**Consultation Response from KC,
Highways Development Management**

2025/92598 Co Op Academy Smithies Moor, Leeds Old Road, Heckmondwike, WF16 9BB

Date Responded: 29-10-2025

SWEPT PATH ANALYSIS - LOW LOADER - LEFT IN

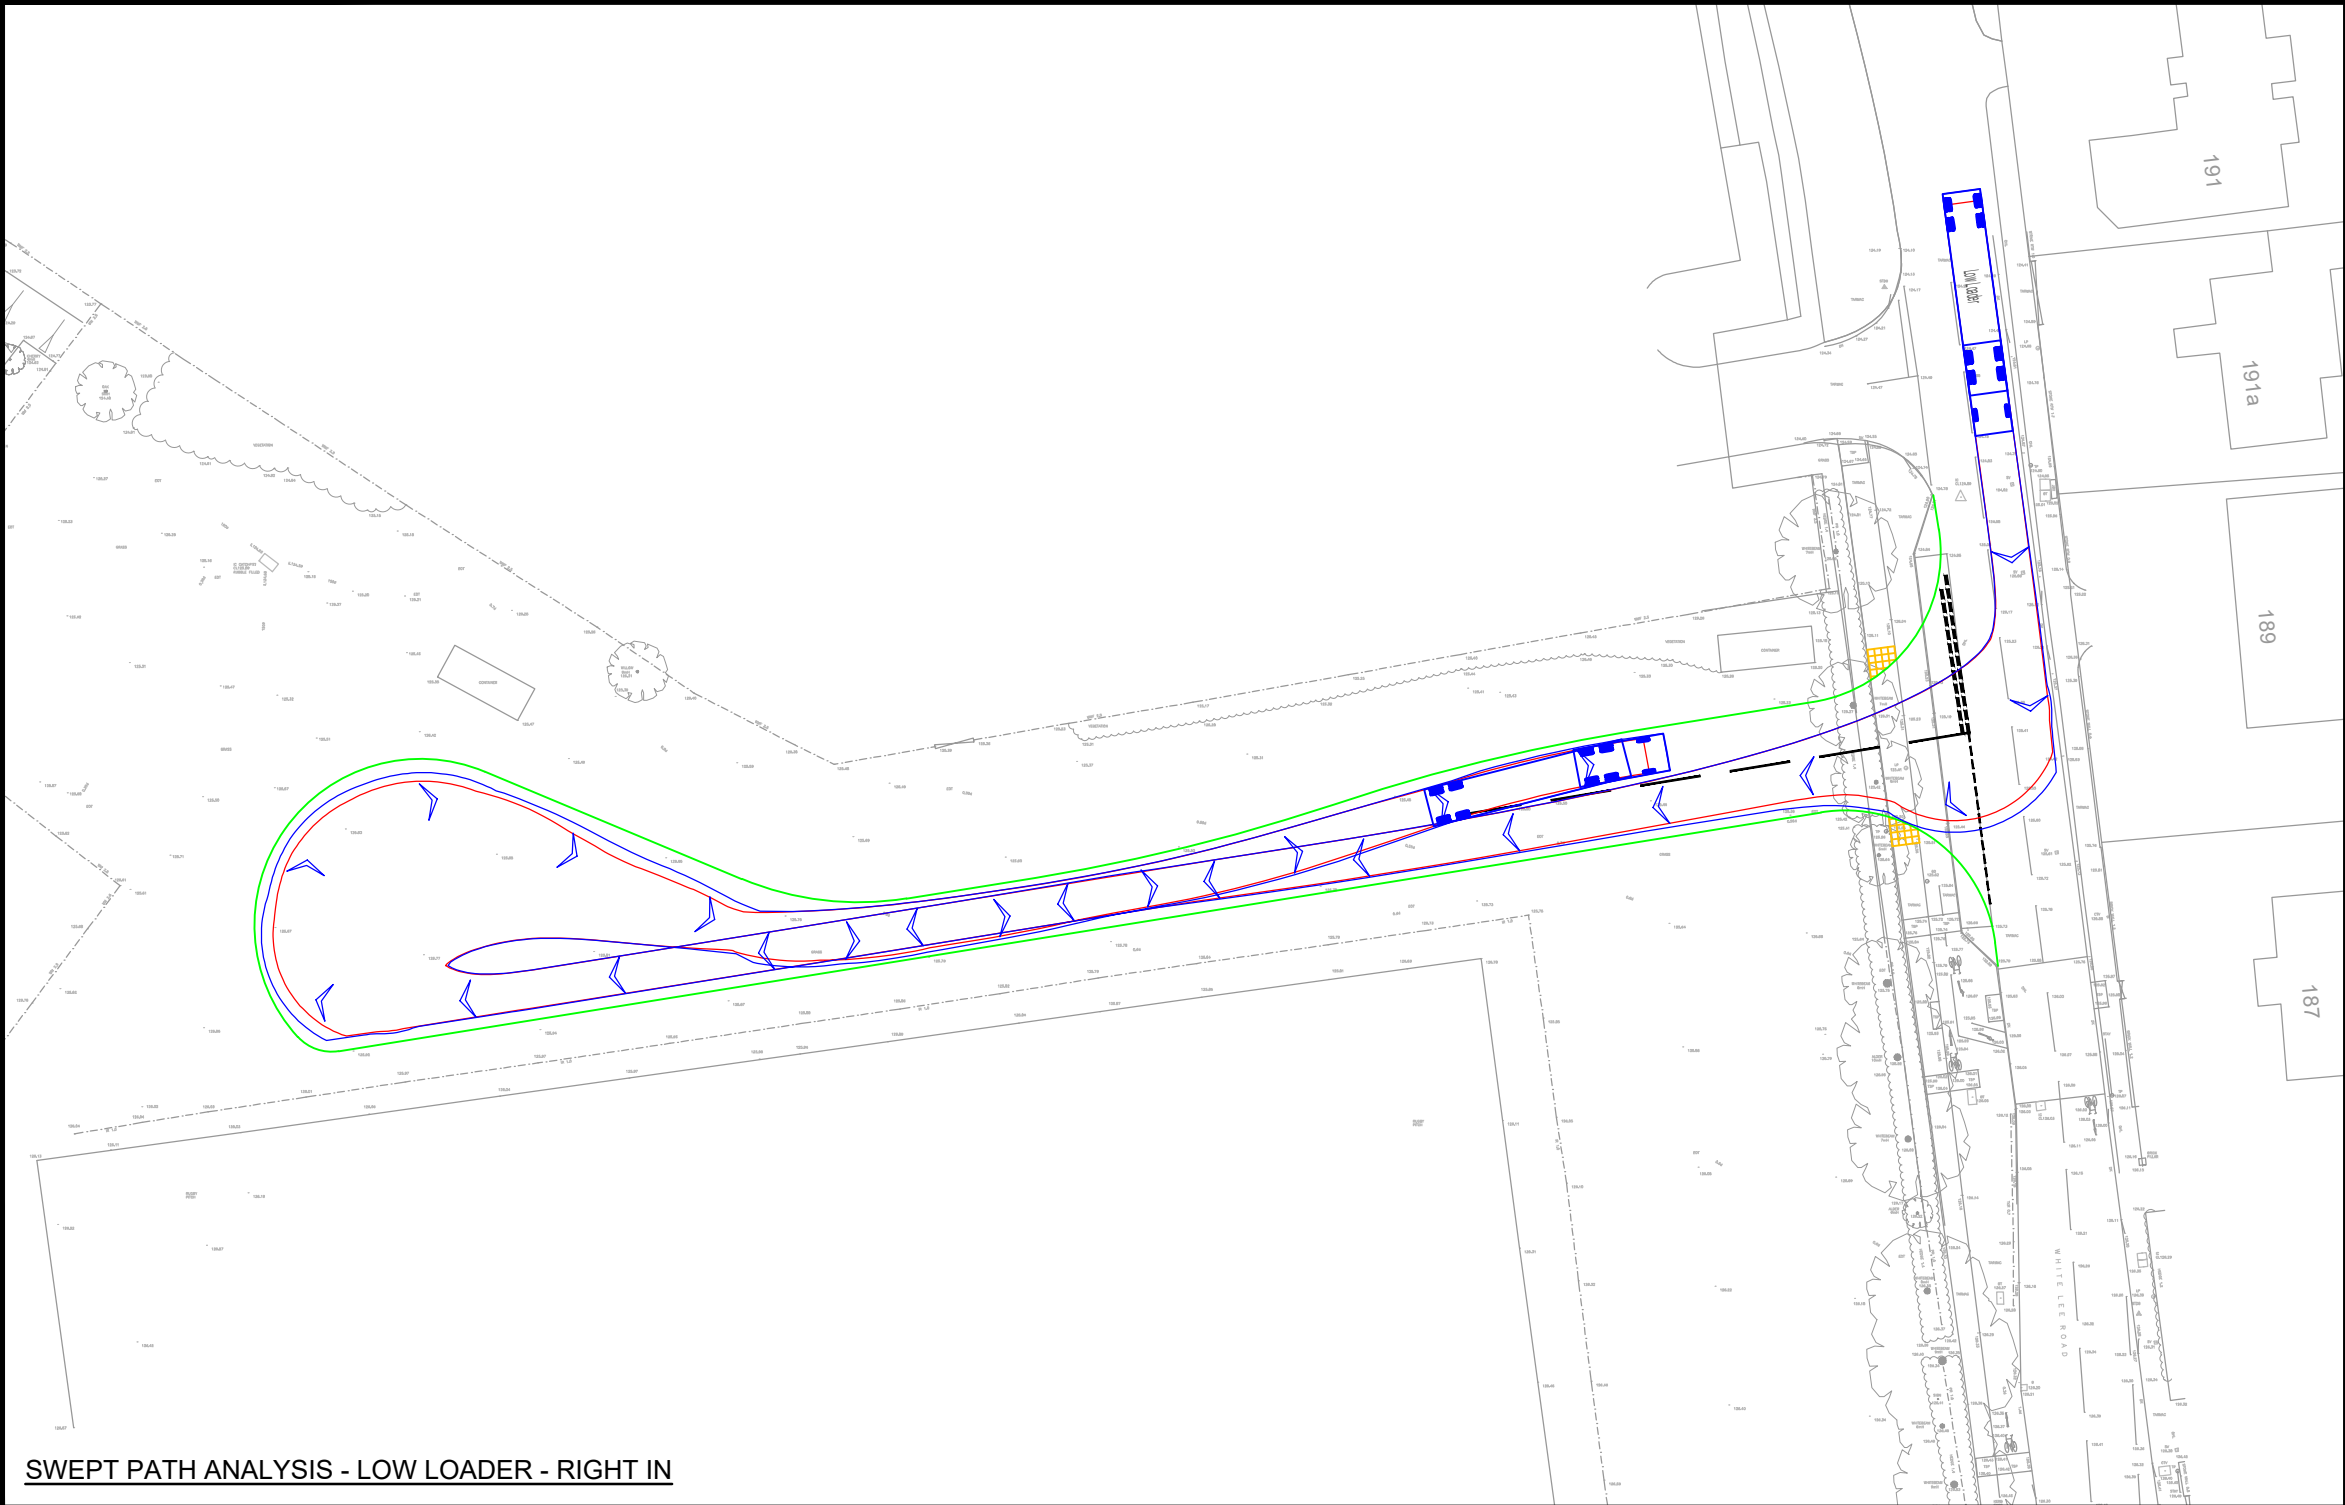
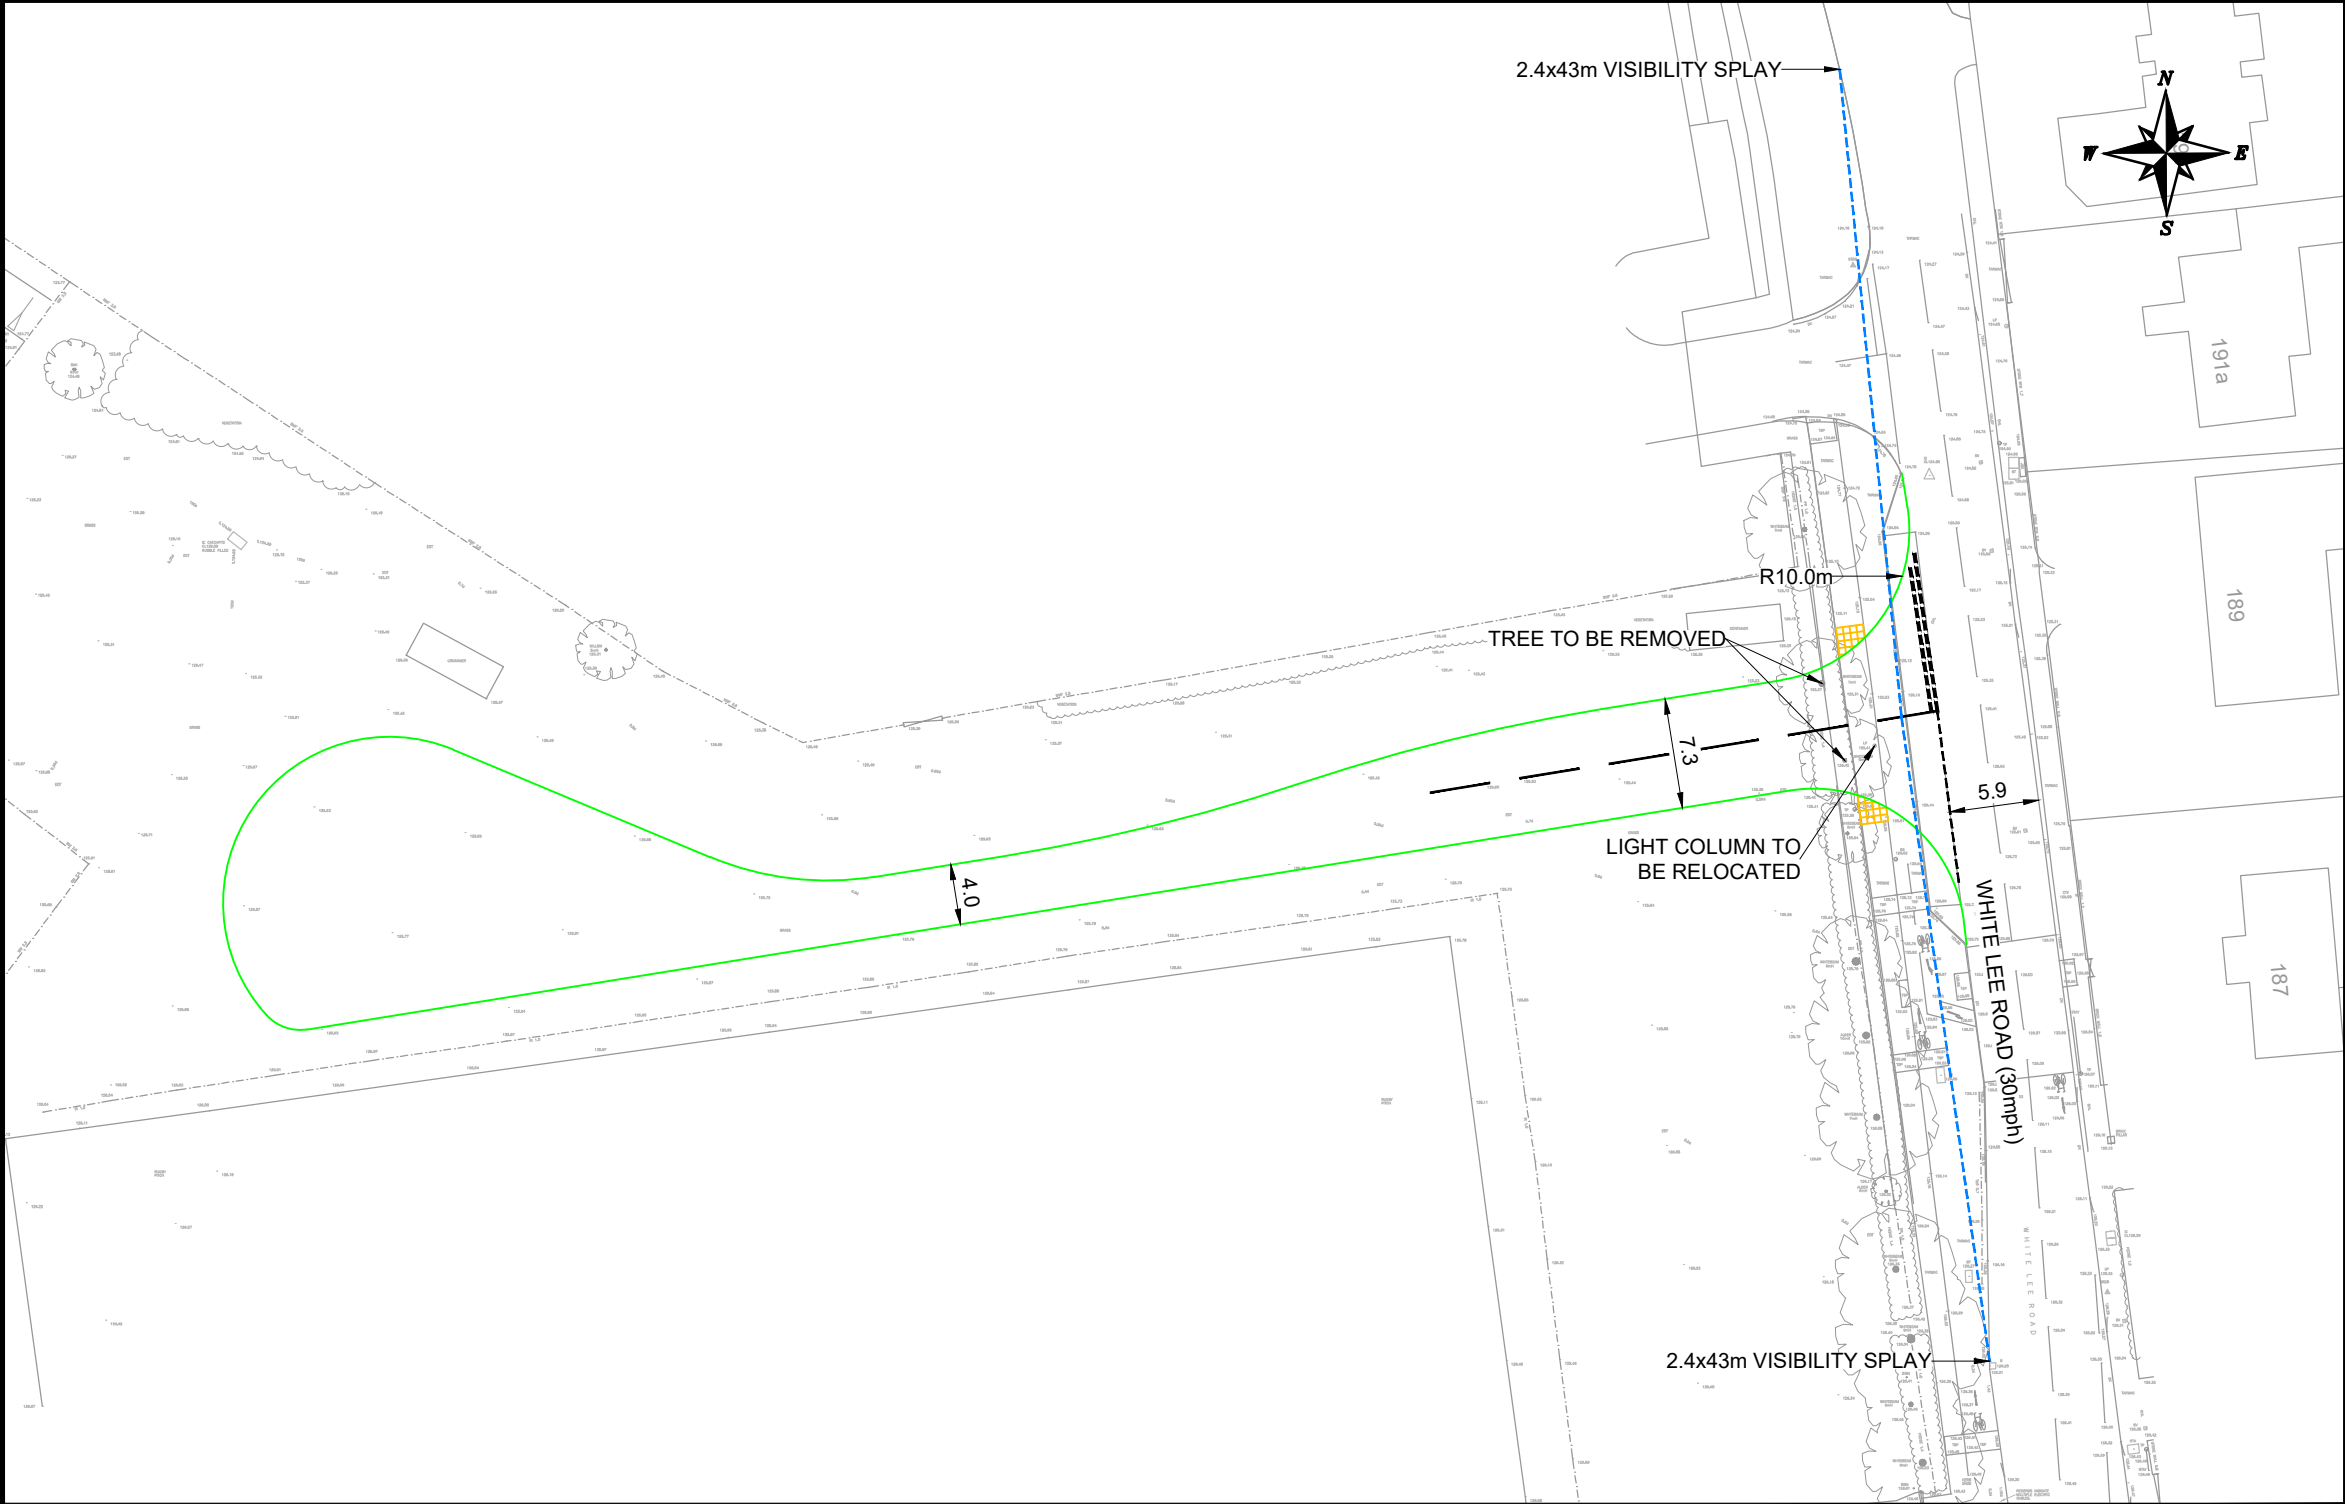
The proposed Construction management plan shows vehicle swept paths which are tight to kerb lines. The access needs to be widened to allow comfortable turning and manoeuvre.

The internal HGV turning shown on this plan is not shown on the construction phase of the works plan. No internal HGV turning is shown for the construction phase of the works.
